**re:**        **Geotechnical Response to City Comments**  
              **Proposed Multi-Storey, Mixed-Use Building**  
              **289 Carling Avenue - Ottawa**

**file:**     PG4801-MEMO.03

Paterson Group (Paterson) prepared the following memo to provide our responses to the geotechnical-related comments issued on November 29, 2019 and prepared by Mr. Mark Fraser at the City of Ottawa.

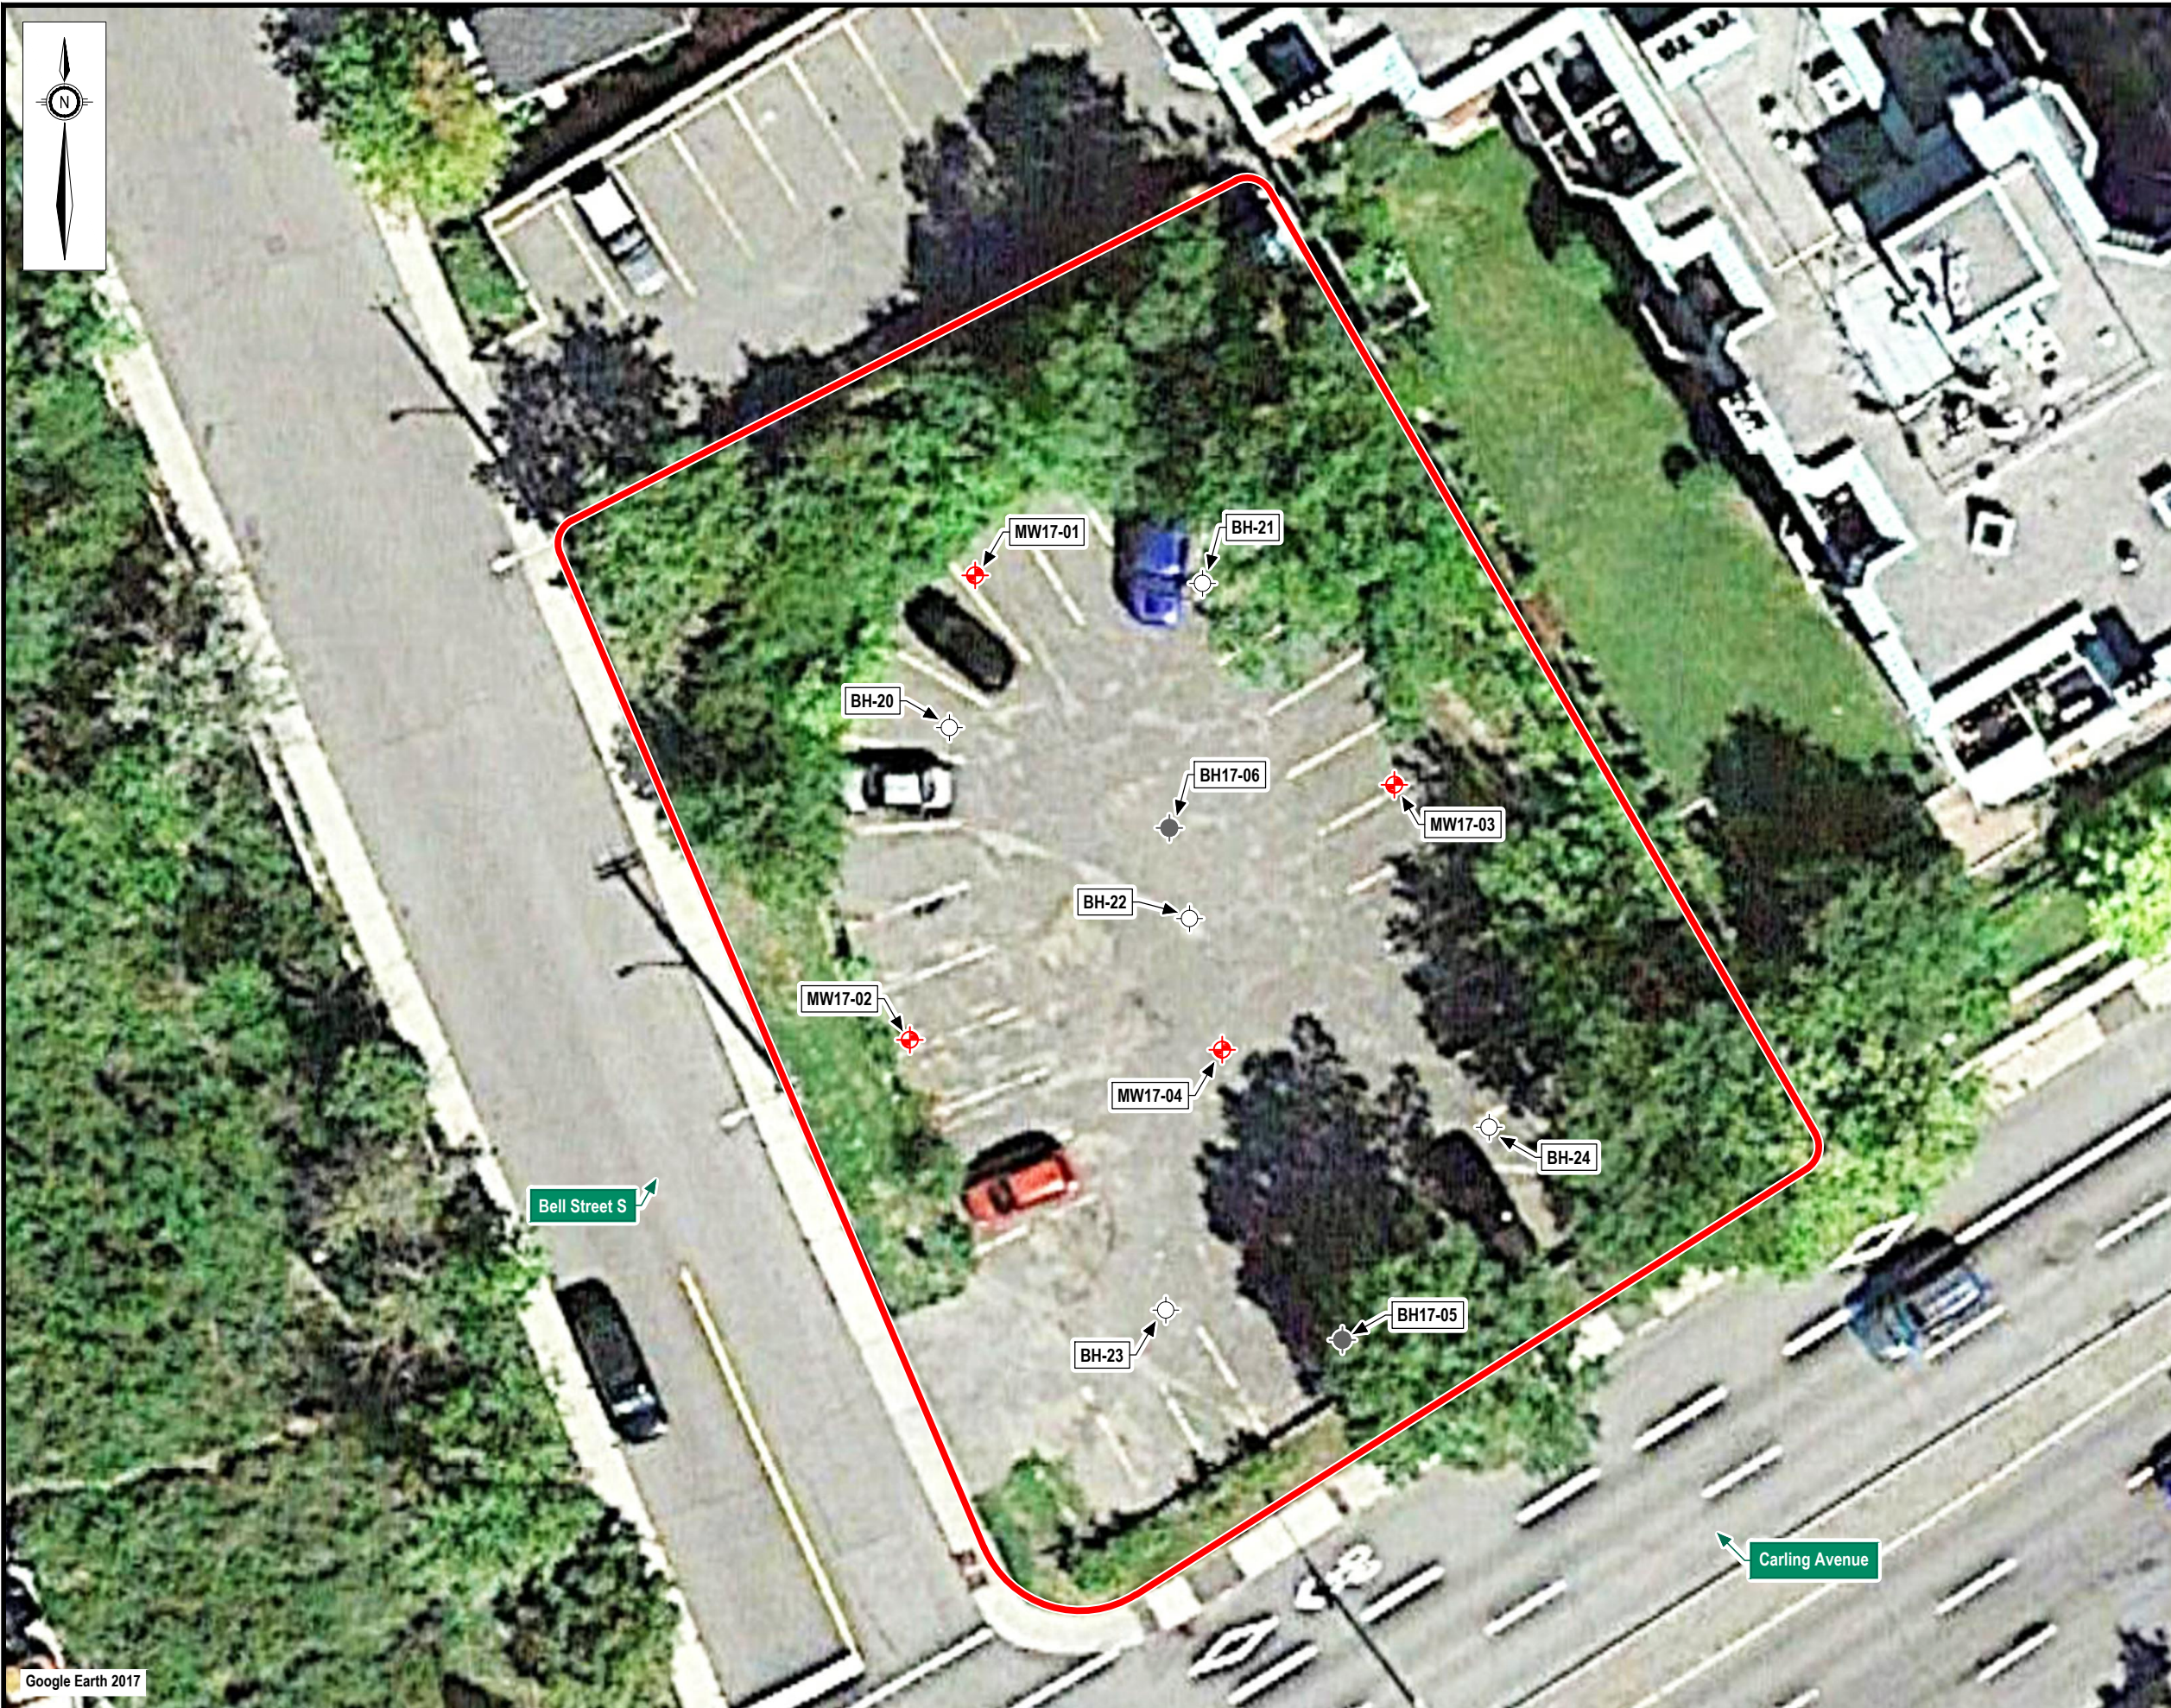
**Comment:** *Please include a summary of the measured groundwater levels on the subject site and provide discussion in relation to the proposed underside of footing. Based on the information provided the building foundation will be below the measured groundwater level thus long-term groundwater discharge from the proposed building subsurface foundation drainage system is anticipated. The sewer outlet for this subsurface drainage system is a combined sewer which is a sensitive system to flow thus total groundwater, sanitary, and stormwater discharge shall not exceed the allowable release rate during a 5-year pre-development storm event. Please quantify the groundwater flow rate that will be discharged to the sewer system and provide to McIntosh Perry for review and consideration in the site servicing design. If the groundwater to be discharged to the sewer is considered high upon review methods and options to provide a water-tight below grade foundation will need to be investigation to control groundwater.*

**Response:** Groundwater level readings were obtained by others in February 2017, at which time the groundwater levels were encountered at depths ranging from approximately 1.4 m to 2.1 m below the existing ground surface. These groundwater levels are documented in the Phase II Environmental Site Assessment dated May 2017 prepared by DST Consulting Engineers.

Correlating the monitoring well locations to nearby spot elevations on the site survey, the groundwater level was encountered at approximate geodetic elevation 70.9 m to 71.4 m. As the lowest level slab for the proposed building is to be located at geodetic elevation 72.0 m, it is anticipated that the invert of the foundation drainage pipes will be located at approximate geodetic elevation 71.6 m.
